**THE HOMESTEAD  
WESTERGATE,  
WEST SUSSEX**

**Design Team Response  
to Stage 1 Road Safety Audit  
25 March 2009**

# **Access to The Homestead Westergate, West Sussex**

Date: 17 March 2009  
Reference: 6902/APT  
Status: Rev A

Drg.Title: SURFACE FINISHES

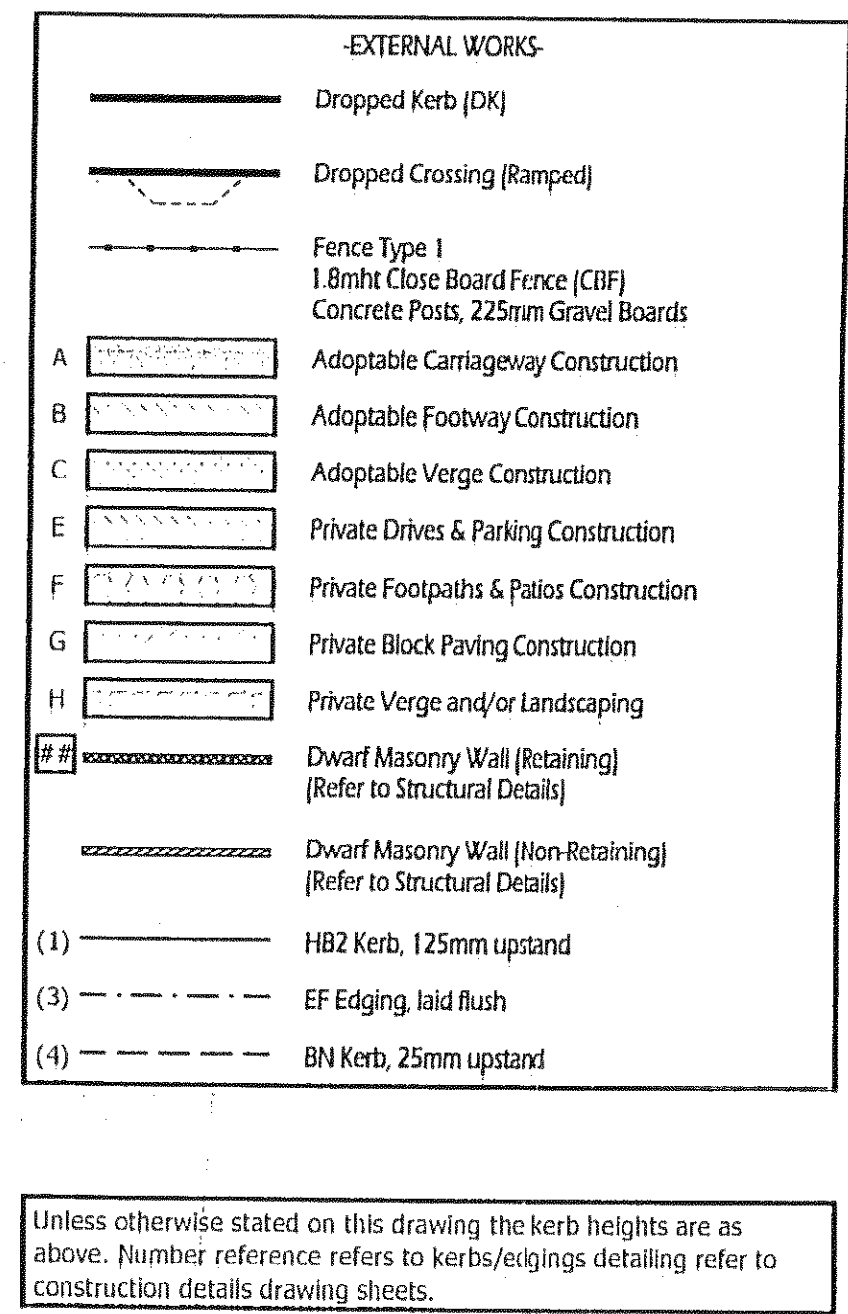
- 2.3 (A5.1) Accepted; This is continued usage of an existing vehicle cross-over of the public footway. Visibility is being radically improved. This is not a public road access and is only a private common driveway for the residents so will not have a road name and is of an adequate status to permit diagram 506.1 signage, which would be misleading to motorists on the public highway. The auditors recommendation has been passed to the developer for consideration of suitable carved stone block or 'private drive' sign plate as may be suitable and permitted by the LPA.
